Subject: DOCO comments for application 2025/91579 at The Homestead, Hurst Knowle, Almondbury, Huddersfield, HD5 8SG

I have reviewed newly submitted documents which are of relevance to designing out crime. My comments are as follows.

PLAN
1 : 50

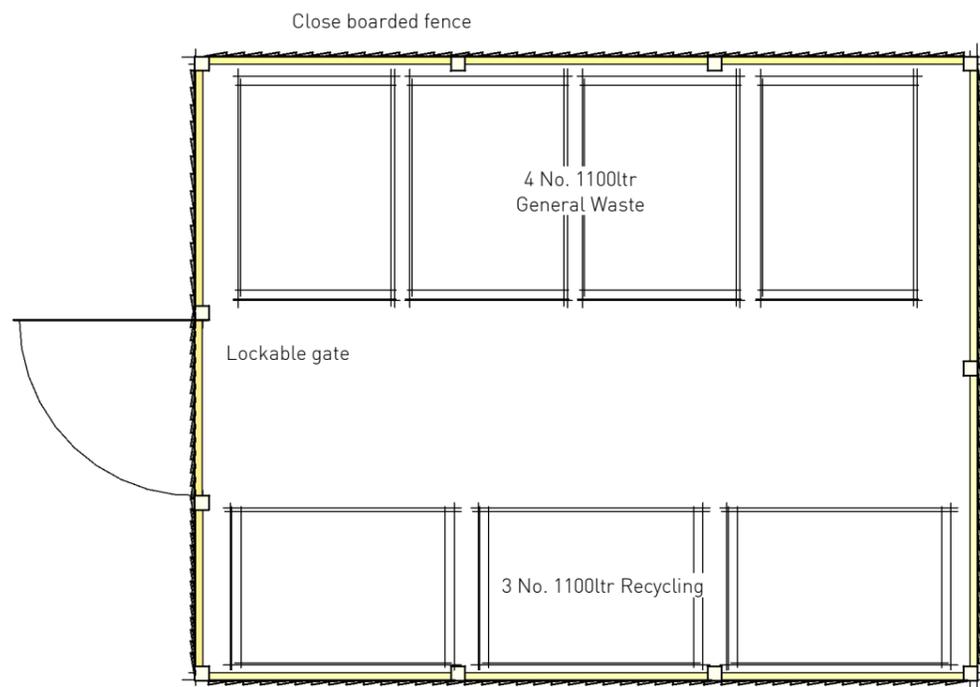
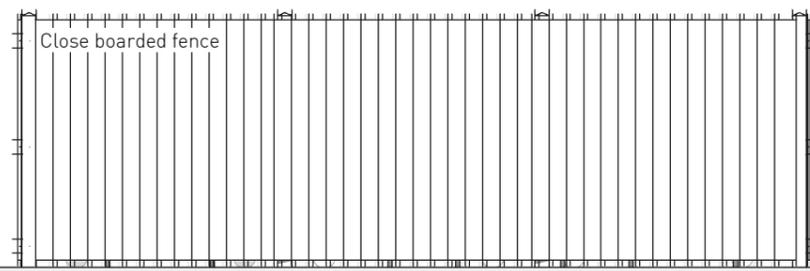
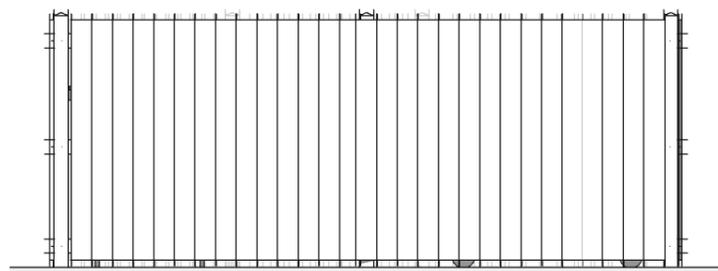
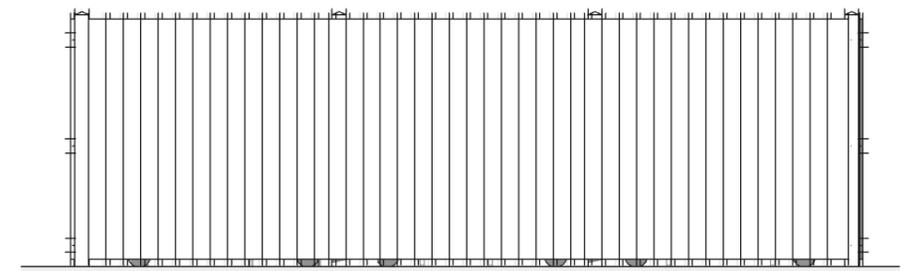
The close boarded fence surrounding the apartment bin store should be at least 1.8m high and subject to access control to prevent its misuse, antisocial behaviour and arson attempts.
